WIDEFIELD WATER AND SANITATION DISTRICT

ROLLING HILLS 2MG POTABLE WATER TANK

2019.829.2030

EL PASO COUNTY, COLORADO

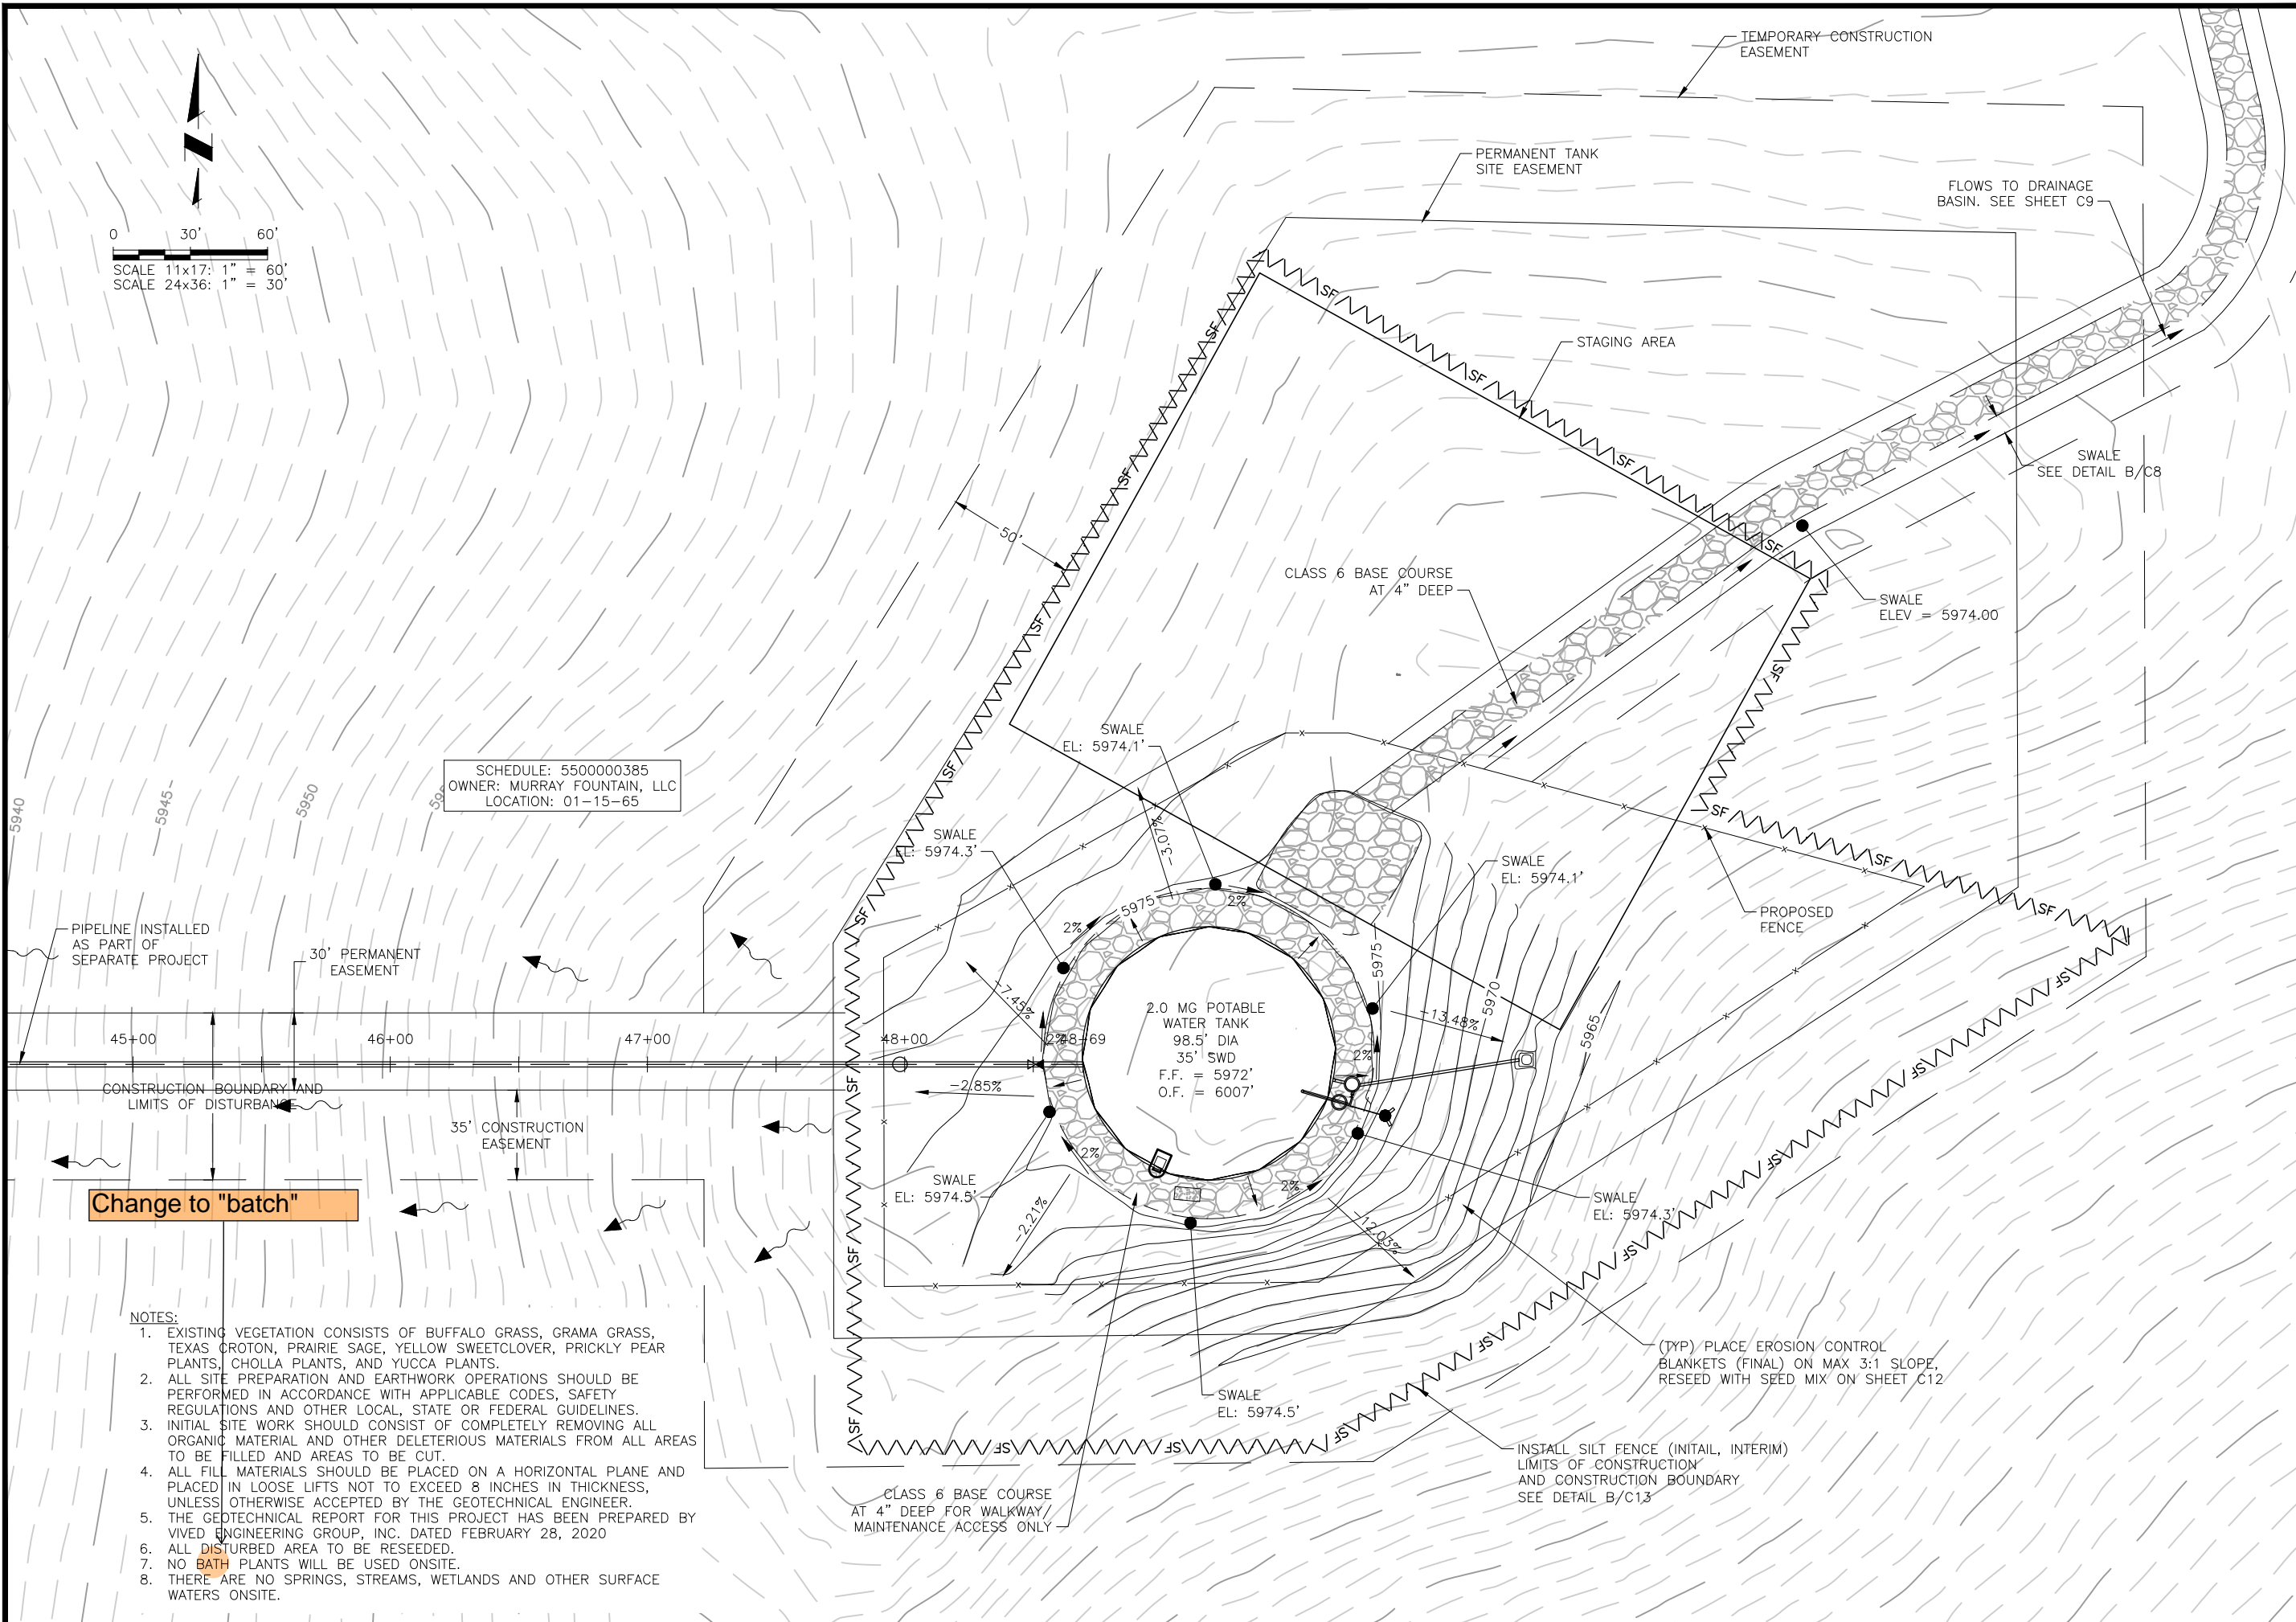
Please identify what the easement is for such as access easement. Please revise any other easements shown on the plans that do not have a designation.
